ASSOCIATED BRITISH PORTS (IMMINGHAM GREEN ENERGY TERMINAL) DEVELOPMENT CONSENT ORDER

TR030008

Response to the Applicant Comments on the Written Representation from PD Ports Services Limited (IP No. 20047065)

Date	3 May 2024
-------------	------------

Work Areas

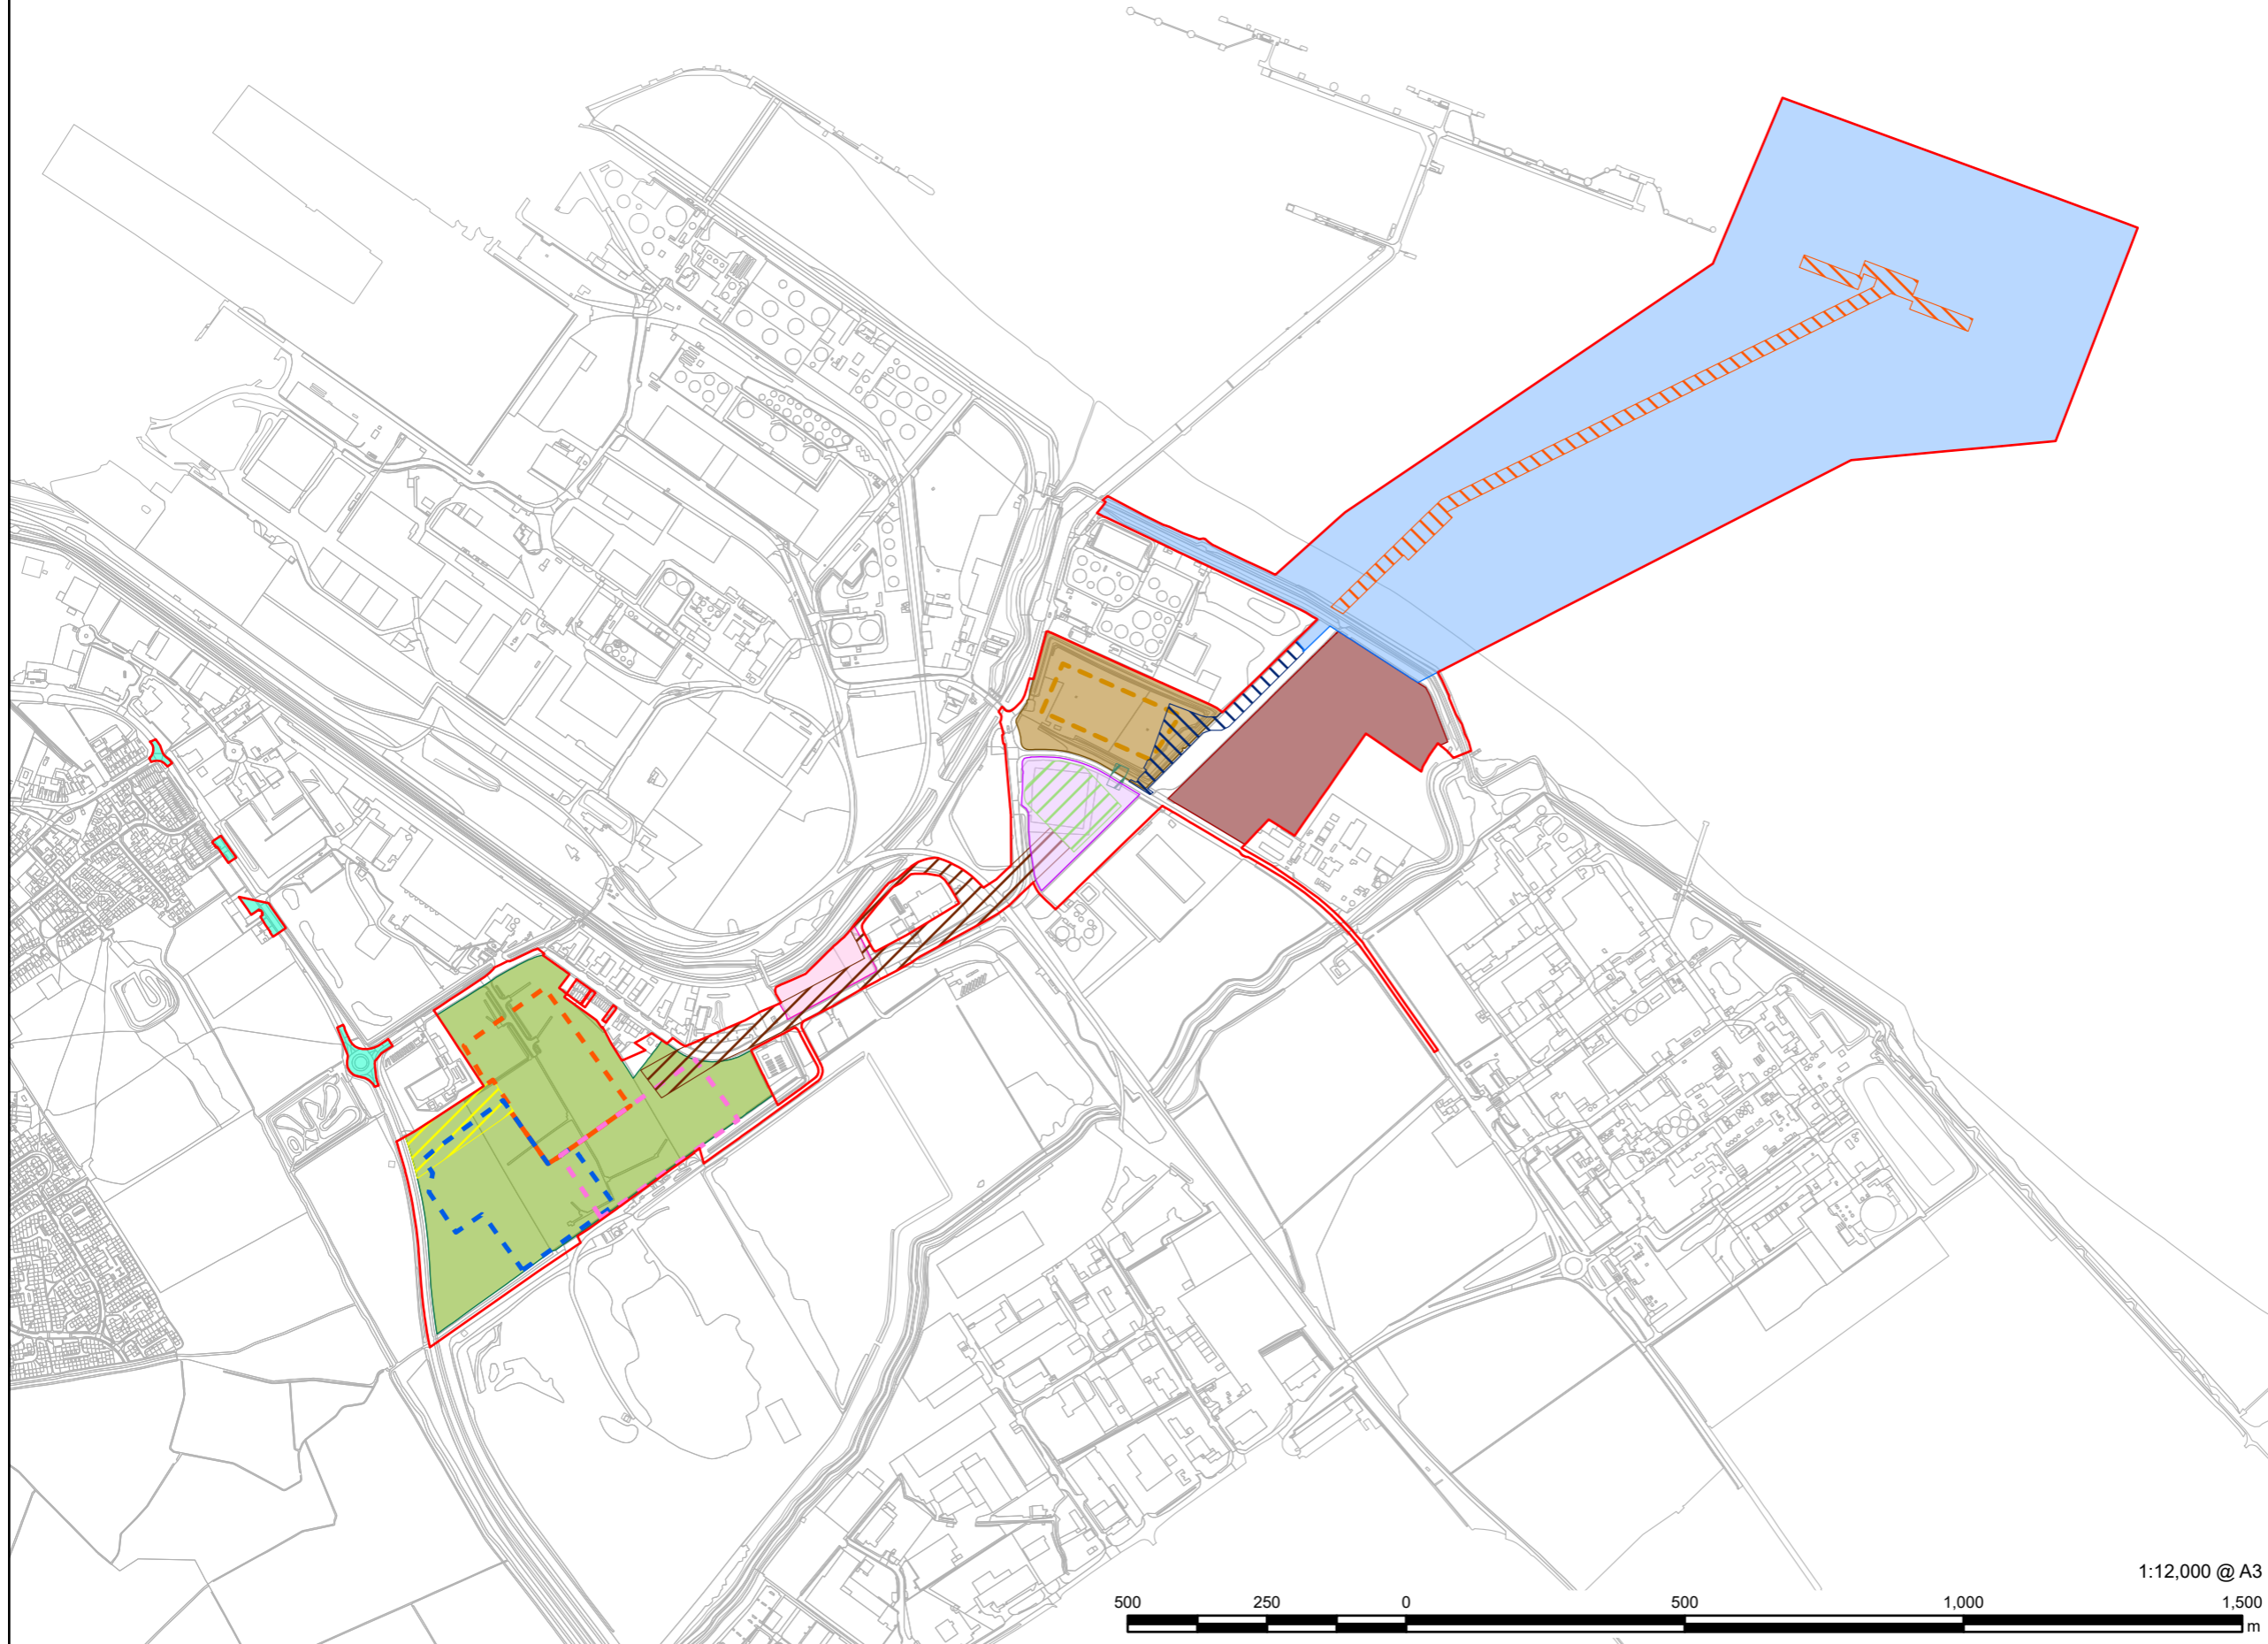
Applicant Comments (March 2024)	PDPS Response (May 2024)
The Applicant welcomes the support for the Project from PDPS and will continue discussions to resolve any outstanding concerns.	Noted.
Vehicle Route	
<p>The design of the culvert (Work No. 4) which is required for the installation of piping and cables under Laporte Road to connect the ammonia storage area (Work No. 3) with the hydrogen production units in Work No. 5 and the jetty (Work No. 1 via Work No. 2) is not yet finalised and, as such, the construction methodology is not yet defined.</p> <p>Several options will be evaluated based on factors including safety of workers and road users, construction practicality/viability and minimising road disruption but with no specific order of preference. However, it is currently anticipated the likely methodology will be a short-term full road closure of Laporte Road in order to excavate the road, place a number of oversized sleeves across the road and then reinstate the road. This will allow the road to be fully re-opened as quickly as possible whilst minimising risk to construction workers. The pipes and cables would be installed in the sleeves at a later date without further work being required on the road surface. This approach has been discussed with the Local Highways Authority.</p>	<p>With regard to the alternative construction techniques, PDPS has raised further queries with the Applicant regarding how this order of preference may be secured and what commitments can be given in this respect in the DCO (protective provisions / requirements). If these installation methods and associated traffic management is to be subject to requirements, then PDPS would wish to be expressly noted as a consultee. Responses from the applicant are awaited.</p> <p>Whilst section 6.1 of the Outline Construction Traffic Management Plan [APP-223] provides for a formal process of liaison between all relevant parties, PDPS is not specifically named. There is therefore no guarantee that PDPS will be consulted.</p> <p>Requirement 7 of Schedule 2 of the draft Development Consent Order provides that that the project may not commence before the CTMP is approved in general accordance with the outline, however it does not name PDPS as a consultee, therefore there is no guarantee that PDPS will be consulted.</p>

<p>The Applicant notes that these figures represent peak construction levels. The averages over the three-year period will be significantly lower.</p>	
<p>Culvert</p>	
<p>As stated in the Applicant's response to 2.2 to 2.7 above, the design of the culvert (Work No. 4) is not yet finalised and, as such, the construction methodology not yet defined. However, the construction of the culvert (Work No. 4) will be carried out in accordance with the dDCO [REP1-016] and relevant control documents such as the Outline Construction Environmental Management Plan [APP-221].</p> <p>As noted by PDPS in its representation, the Applicant has confirmed that once the culvert has been installed, the road will be of similar strength to the rest of the public highway.</p>	<p>Further queries have been raised with the Applicant in relation to how such assurances/commitment will be secured in the DCO. The highways works associated with the culvert design do not appear to form part of proposed requirement 8 (Highways Works); it is suggested that approval of the culvert works are added to this requirement and that PDPS should be named as a consultee.</p>

<p>Article 8 of the draft DCO (“dDCO”) [REP1-016] sets out the extent of application of the New Roads and Street Works Act 1991 (“the 1991 Act”) to street works under the dDCO. The general requirements as to execution of street works under the 1991 Act apply and include an obligation on the undertaker to avoid unnecessary delay or obstruction.</p> <p>It is accepted that a road closure of Laporte Road for two to four weeks would result in a 3.5 mile diversion for traffic from East Gate to PDPS. Typically, this would only add approximately 10 minutes to journey time. Other traffic from the East Gate would be less affected because their typical routes are less direct than for PDPS.</p>	
<p>Temporary access off Laporte Road</p>	
<p>As stated in the Applicant’s response to ExQ1.13.3.1, submitted at Deadline 1 [REP1-034], the Laporte Road Temporary Construction Area (Work No. 9) will be required for approximately three years, being the full duration of Phase 1 of construction of the Project.</p> <p>It is intended that the Laporte Road Temporary Construction Area (Work No. 9) will be used for materials/equipment storage and car parking for the East Site (Work Nos. 1 to 6). Large abnormal loads (and, wherever practicable, other items) will be transported directly to the final location and not to the Work No. 9 laydown area. Work No. 9 is not intended to be used as a Temporary Construction Area for Work No. 7.</p> <p>Table 6 of the Outline Construction Traffic Management Plan [REP1-006] confirms that only 59 Heavy Goods Vehicles per day (less than six per hour) are forecast to use Laporte Road (and therefore the Queens Road/Laporte Road junction). In addition, it is forecast to accommodate access for 447 construction worker movements per day (Table A-2 in Appendix A of the Outline Construction Traffic Management Plan). Peak hour flows will be less than 70 vehicles. These will predominantly be movements from Queens Road (S) to Laporte Road (W) or vice versa and will therefore have no impact on queuing inbound to the port or on safety or operation of adjacent access for PDPS.</p> <p>Clearly, given these very low flows and limited impact, there can be no justification or requirement to limit the use of Work No. 9 in traffic impact terms.</p>	<p>The traffic movements to the construction compound identified may have the effect of creating queuing traffic which might obstruct access to PDPS’s site, especially if barrier control or a checkpoints are installed. It is therefore important that PDPS are identified as a consultee in the requirements relating to the approval of the final details of the Construction Traffic Management Plan.</p>
